Please ask for: Ms Iqraa Malik
Email: iqraa.malik@terraquest.co.uk
Telephone: 01212341390
Our Ref: Y/7/21/HH
Your Ref:
Date: 21st January 2021

Application for Planning Permission for Works or Extension to a Dwelling

Development: Would like to apply to have a dropped kerb
Location: 14 East Bank North End Road Yapton BN18 0DJ

Proposed Plan - 1:100 @A1

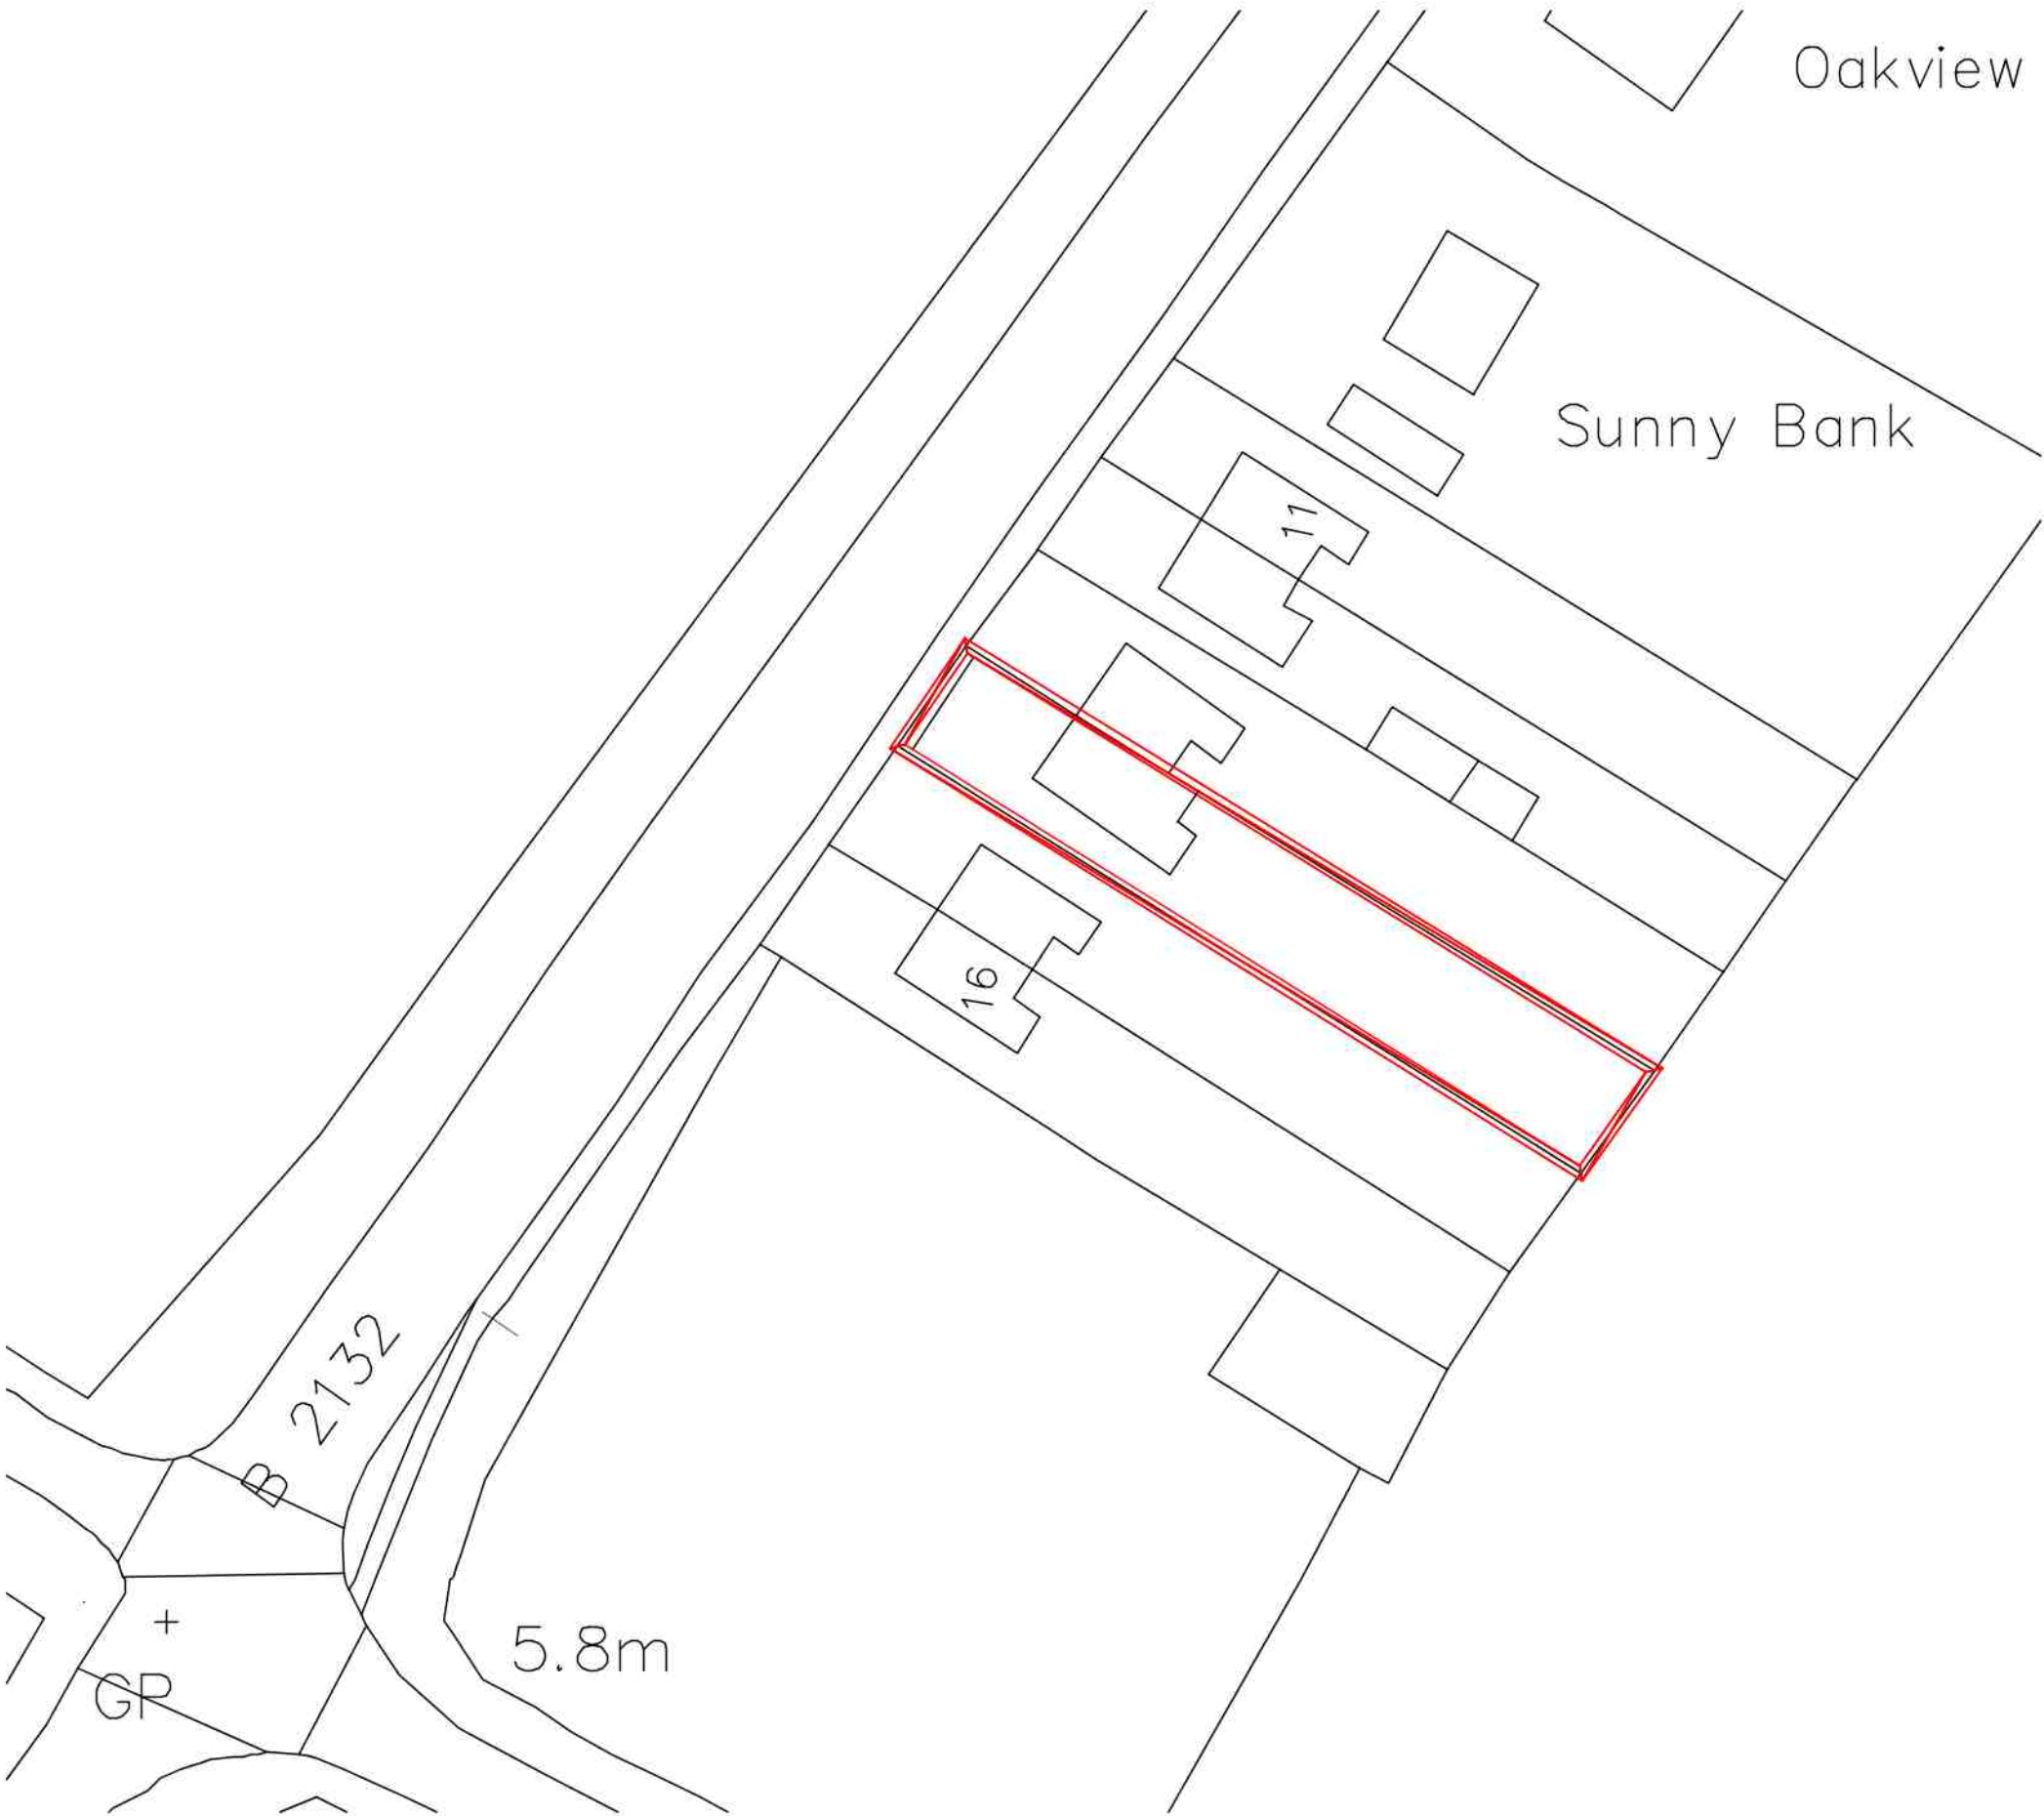
Confirmation: Please confirm what you are applying for as the plans are showing a proposed extension. If you are proposing an extension then a full set of proposed and existing floor plans and elevations are required.

Visibility Splays - 1:500 @A1

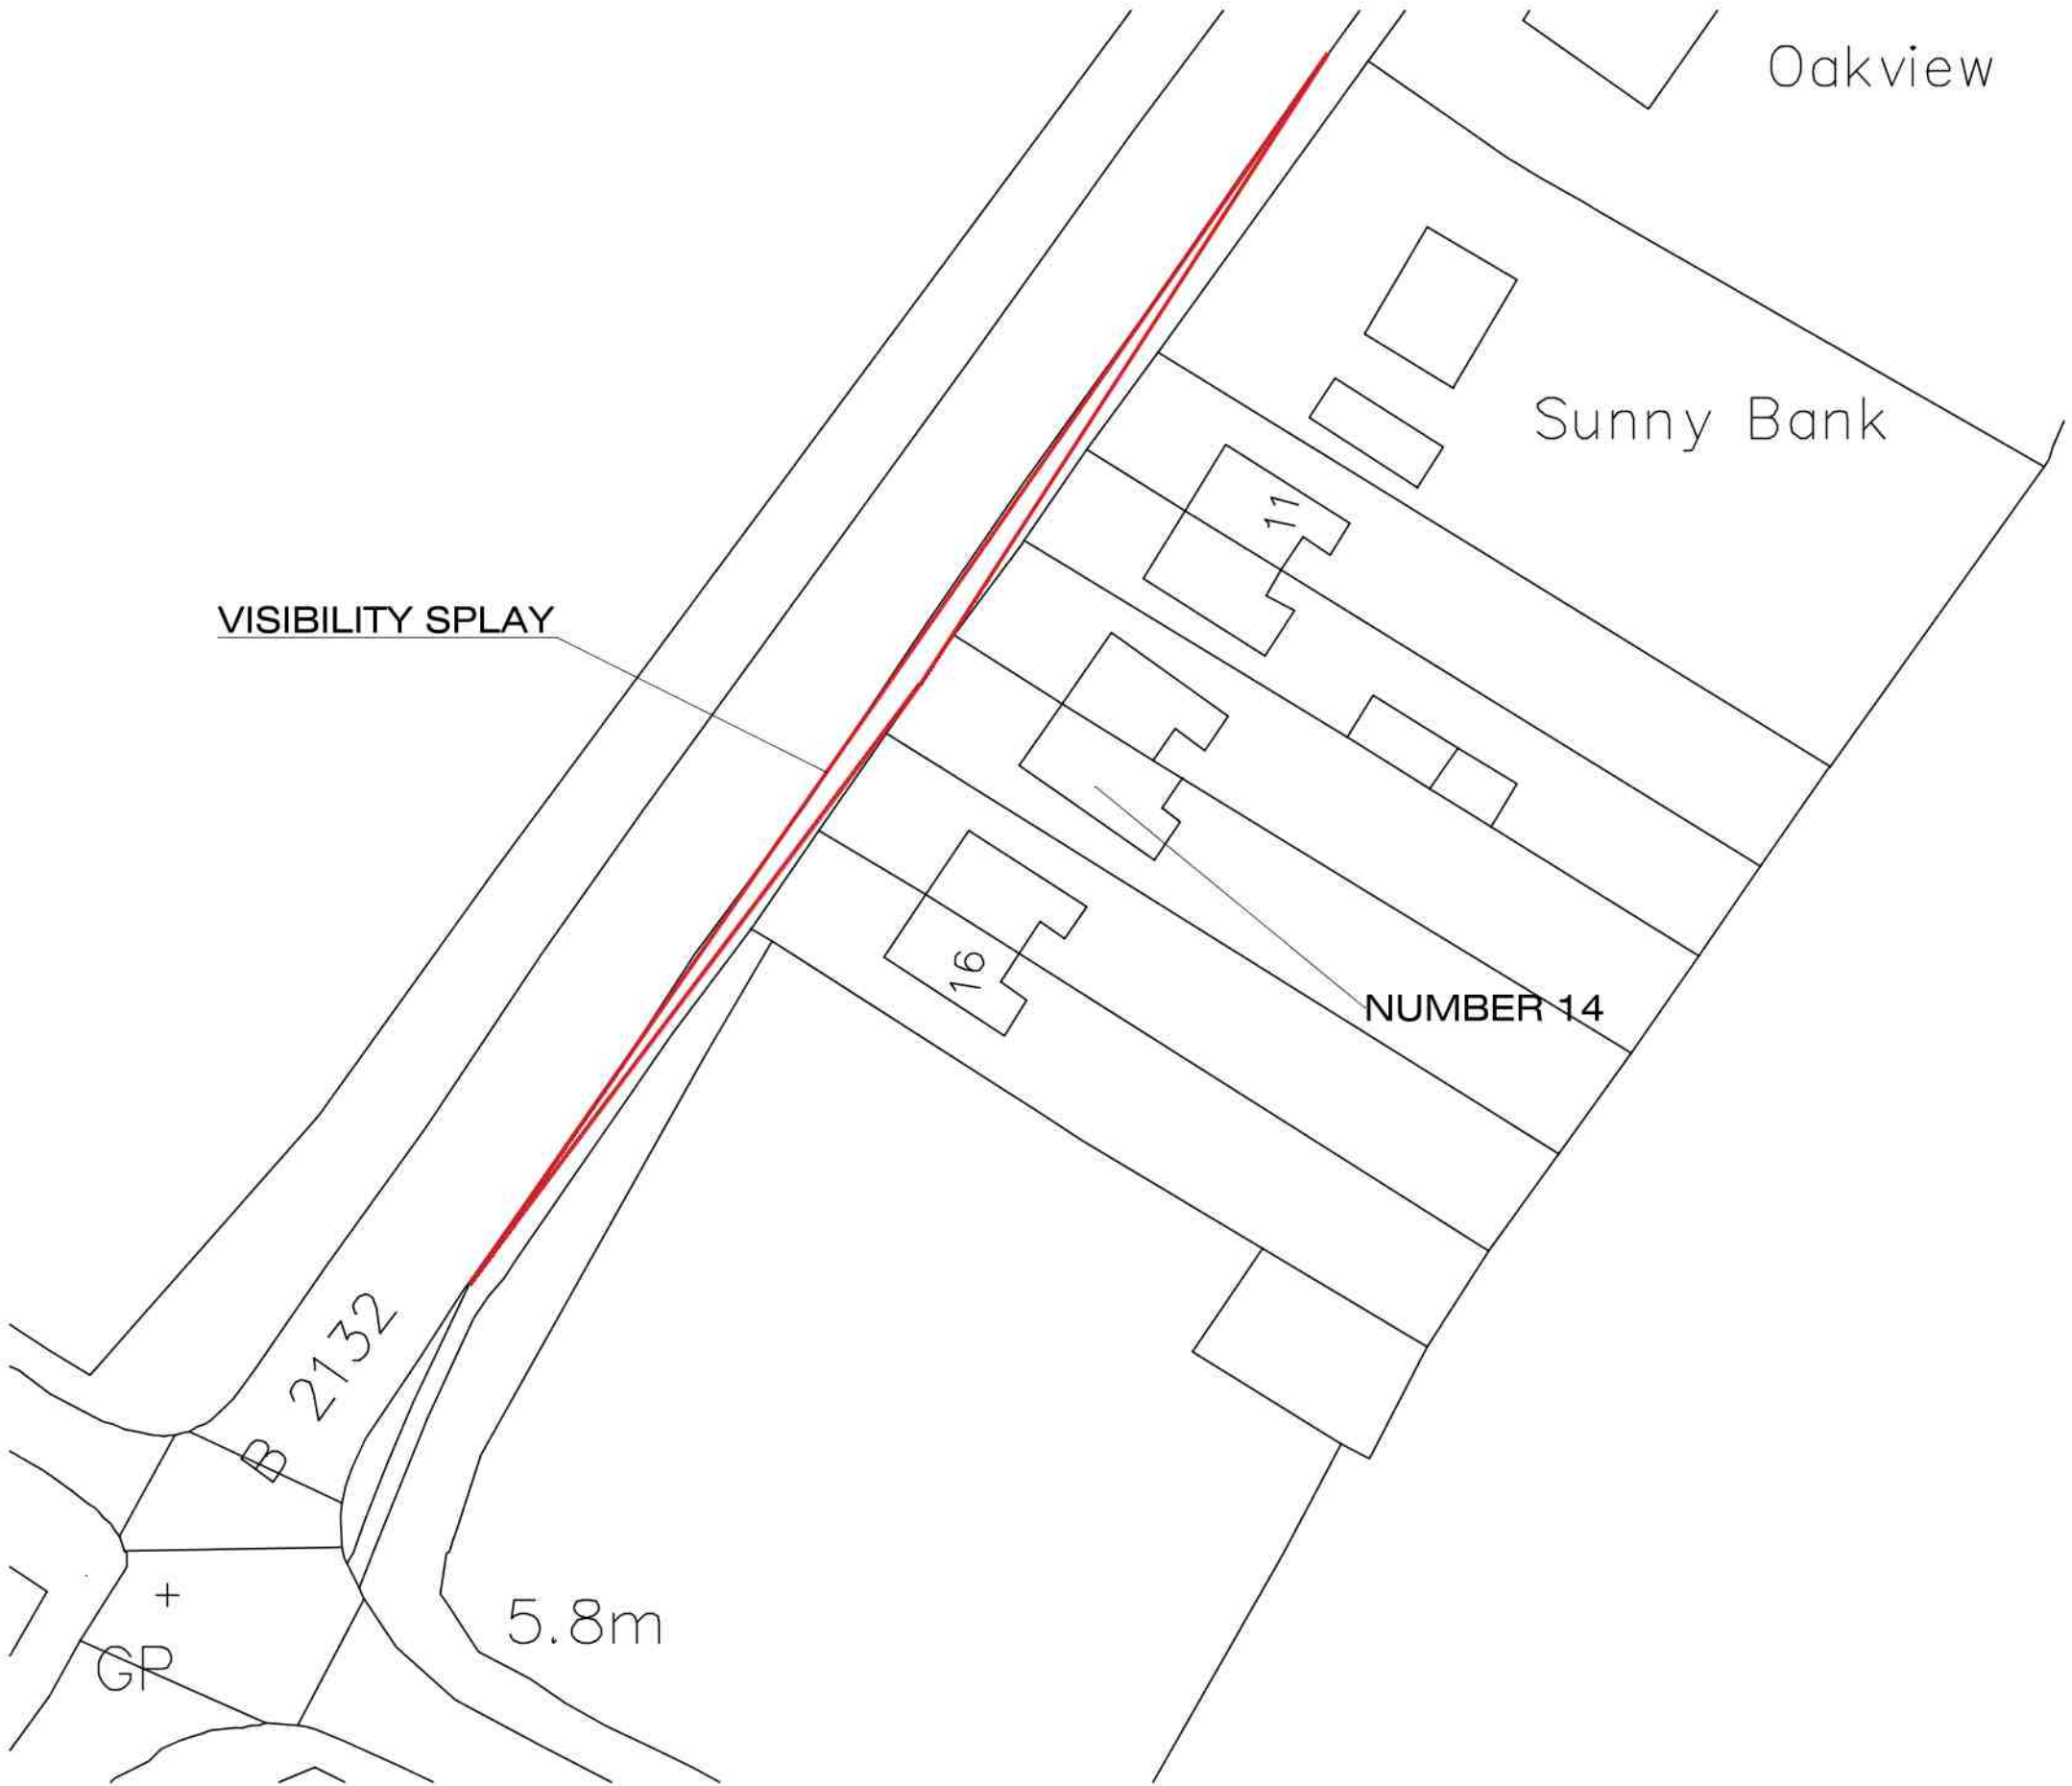
West Sussex County Council require that a visibility splay is provided. A splay is formed for a 30 mph speed limit road by measuring from a point 2.4m back from the kerb edge in the centre of the proposed access. A line should then be drawn from either side of this point for 43 m in each direction to the nearside edge of the carriage way. The splays must intersect and only within the control of the applicant, or within the publicly maintained highway.

The distance will increase with the speed limit of the road. If the road is 40 mph speed limit then the distance should be 120 m either side. For speeds above this please contact West Sussex County Council Highways for advice on what would be acceptable.
